**PONDEROSA PINES BOUNDARY LINE ADJUSTMENT (BL-20-00013)  
COMPLIANCE DOCUMENT**

DWN BY	DATE	JOB NO.
G.W.	10/2020	080202
CHKD BY	SCALE	SHEET
D.L.P.	1" = 200'	1 OF 4

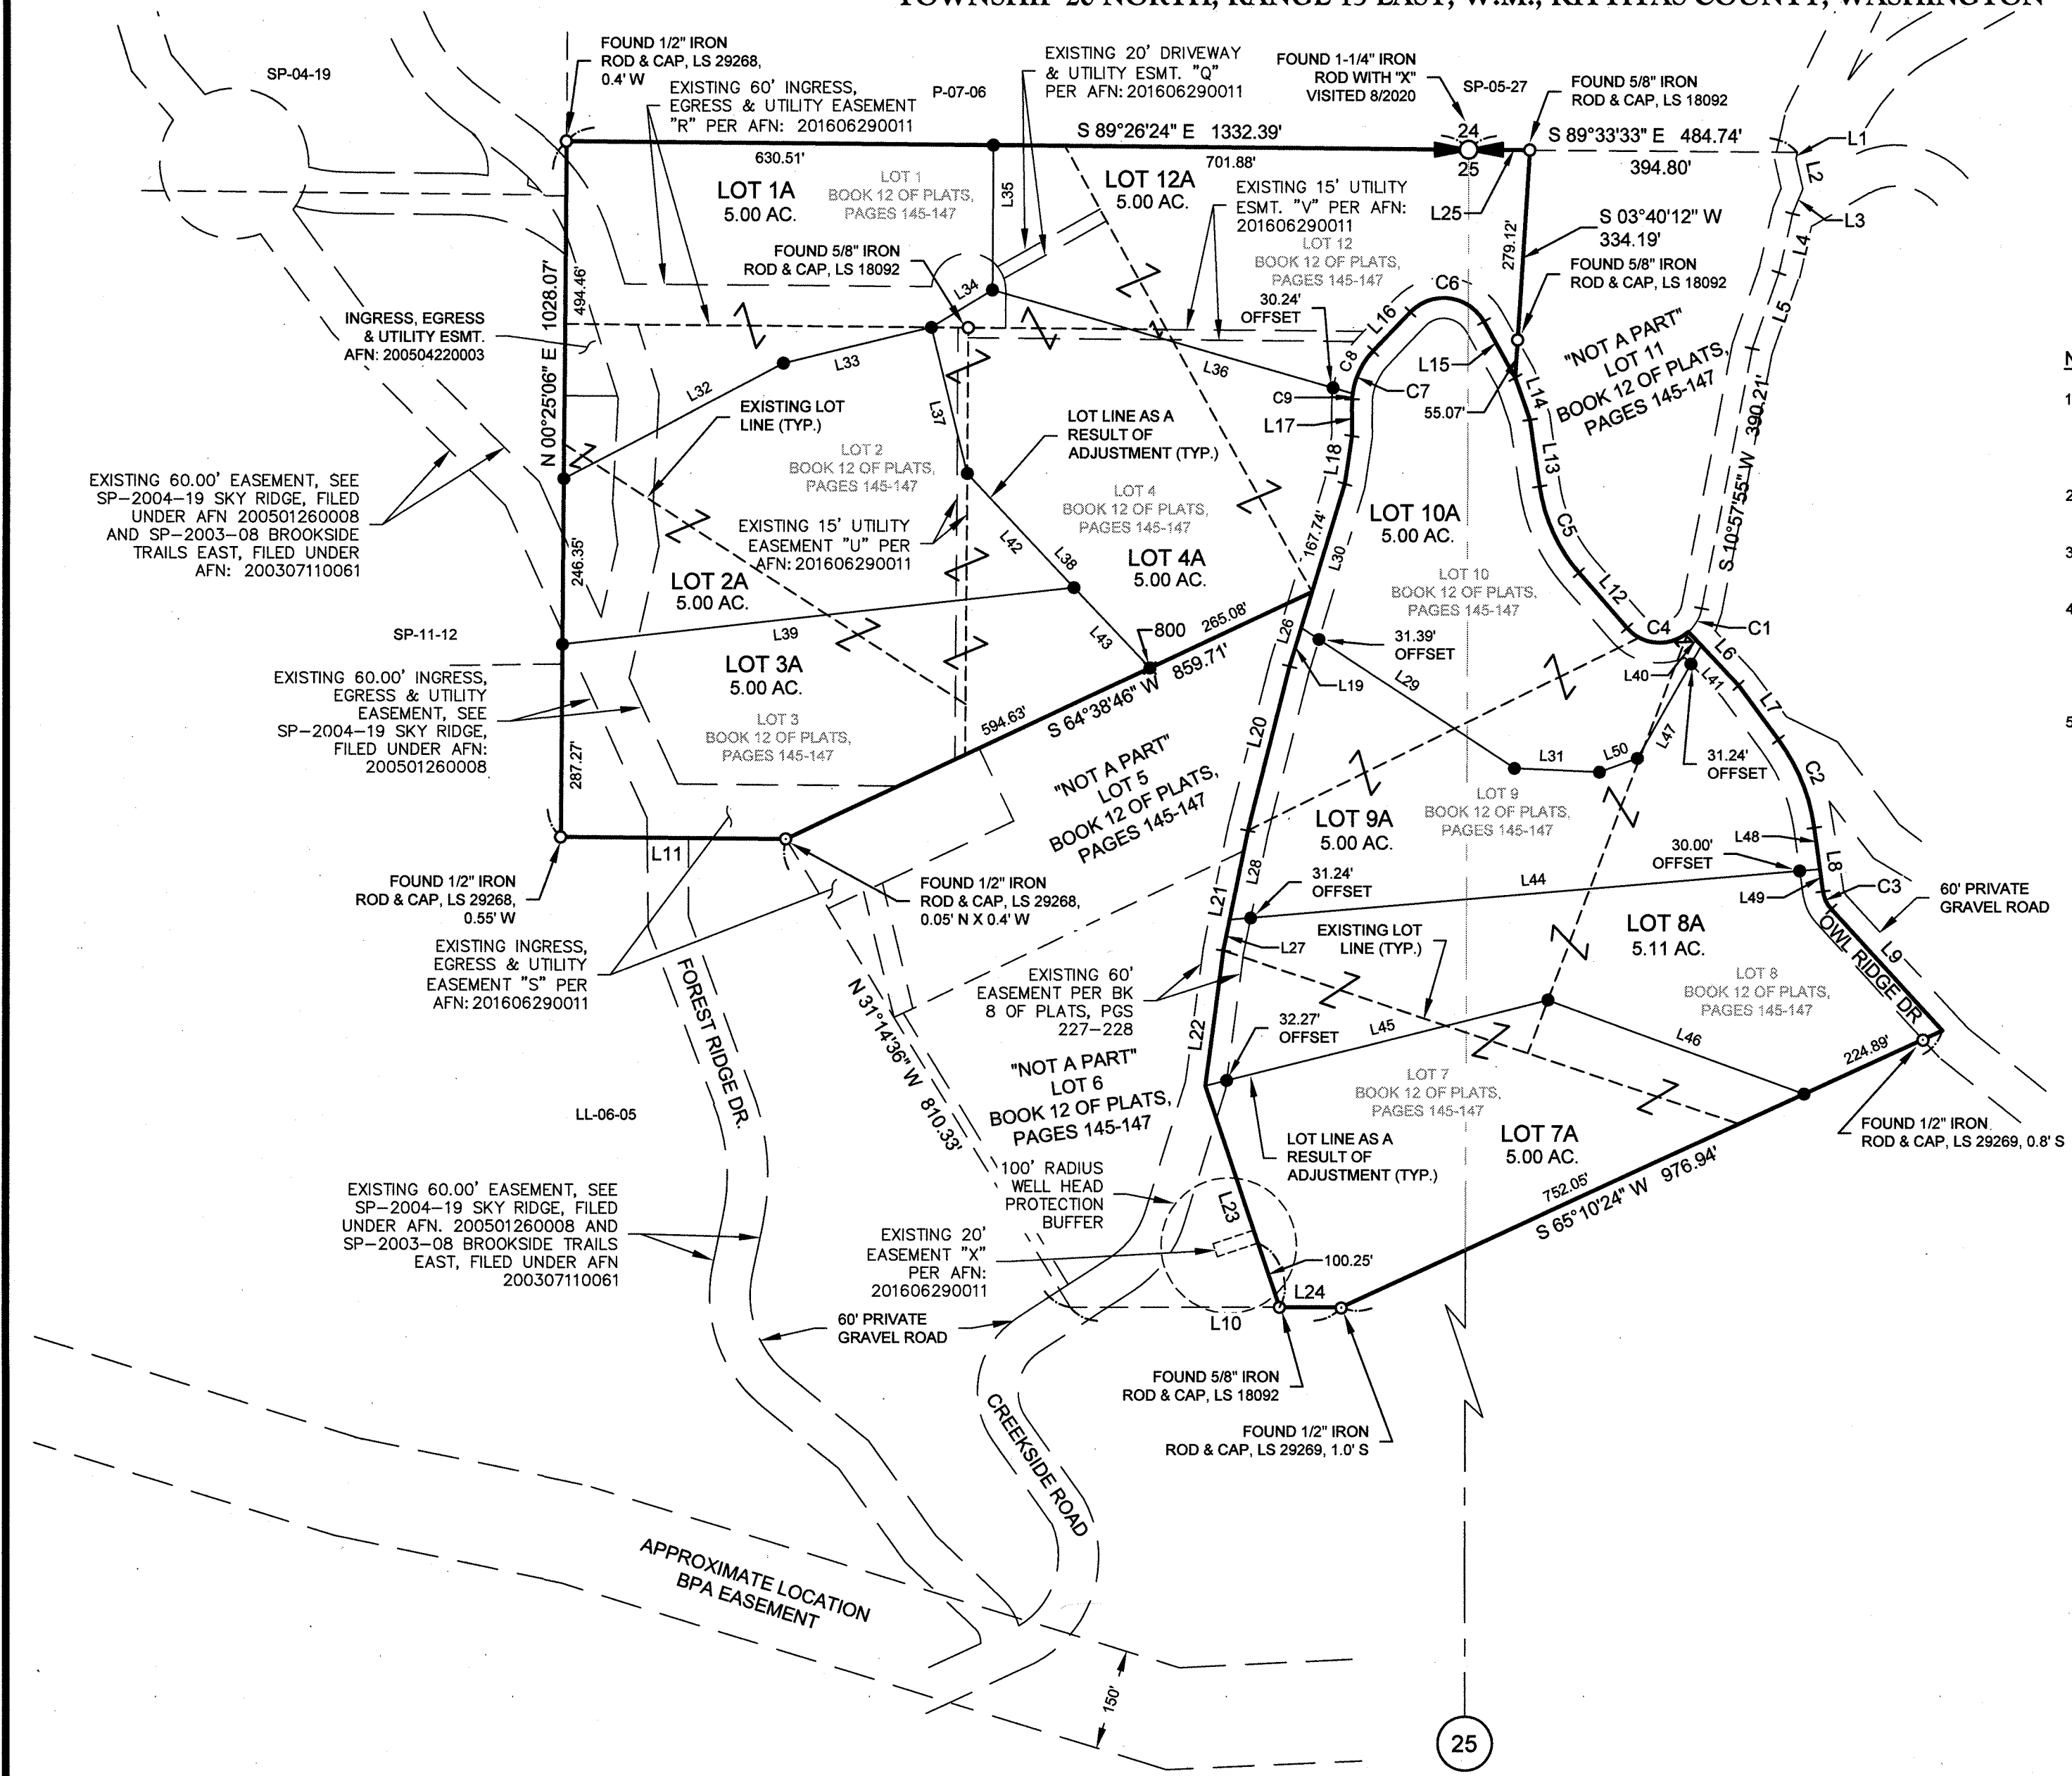
MAY 7, 2020	PUBLIC WORKS PLANNING REVIEW TEAM	ITEM c: (APPLICANT NEEDS TO BE AWARE OF THE FOLLOWING) ANY FURTHER SUBDIVISION OR LOTS TO BE SERVED.....	NOTED
MAY 7, 2020	PUBLIC WORKS PLANNING REVIEW TEAM	ITEM d: (APPLICANT NEEDS TO BE AWARE OF THE FOLLOWING) EVIDENCE OF EXISTING ACCESS AND/OR EVIDENCE....	NOTED
MAY 7, 2020	PUBLIC WORKS PLANNING REVIEW TEAM	ITEM e: (APPLICANT NEEDS TO BE AWARE OF THE FOLLOWING) ACCESS IS NOT GUARANTEED TO ANY EXISTING OR CREATED PARCEL....	NOTED
MAY 7, 2020	PUBLIC WORKS PLANNING REVIEW TEAM	SUGGESTIONS (NOT REQUIRED) 1. BLA WILL NEED SURVEYOR STAMP, SIGNATURE & STATEMENT	PLACED ON FINAL SHEETS
MAY 7, 2020	PUBLIC WORKS PLANNING REVIEW TEAM	SUGGESTIONS (NOT REQUIRED) 2. EQUIPMENT & PROCEDURE STATEMENT IS MISSING.	PLACED ON FINAL SHEET
MAY 7, 2020	PUBLIC WORKS PLANNING REVIEW TEAM	SUGGESTIONS (NOT REQUIRED) 3. AUDITOR’S CERT. IS MISSING	PLACED ON FINAL SHEETS
MAY 7, 2020	PUBLIC WORKS PLANNING REVIEW TEAM	SUGGESTIONS (NOT REQUIRED) 4. PURPOSE OF SURVEY STATEMENT IS MISSING	PLACED ON FINAL SHEET

<b>DATE OF COMMENT</b>	<b>NAME/AGENCY</b>	<b>REDUCED COMMENT</b>	<b>APPLICANT RESPONSE</b>
MAY 7, 2020	PUBLIC WORKS PLANNING REVIEW TEAM	SUGGESTIONS (NOT REQUIRED) 5. BASIS OF BEARINGS IS MISSING	PLACED ON FINAL SHEETS
MAY 7, 2020	PUBLIC WORKS PLANNING REVIEW TEAM	SUGGESTIONS (NOT REQUIRED) 6. SECTION, TOWNSHIP & RANGE TO BE SHOWN ON TOP OF PAGES	PLACED ON FINAL SHEETS
MAY 7, 2020	PUBLIC WORKS PLANNING REVIEW TEAM	SUGGESTIONS (NOT REQUIRED) 7. ROAD WIDTHS, OWNERSHIP & SURFACING INFO	PLACED ON FINAL SHEET
MAY 7, 2020	PUBLIC WORKS PLANNING REVIEW TEAM	SUGGESTIONS (NOT REQUIRED) 8. MISSING LEGEND	PLACED ON FINAL SHEET
MAY 7, 2020	PUBLIC WORKS PLANNING REVIEW TEAM	SUGGESTIONS (NOT REQUIRED) 9. SHOW WHERE PRIVATE ROADS CONNECT TO COUNTY ROAD SYSTEM	SEE SHEET 4 OF 4
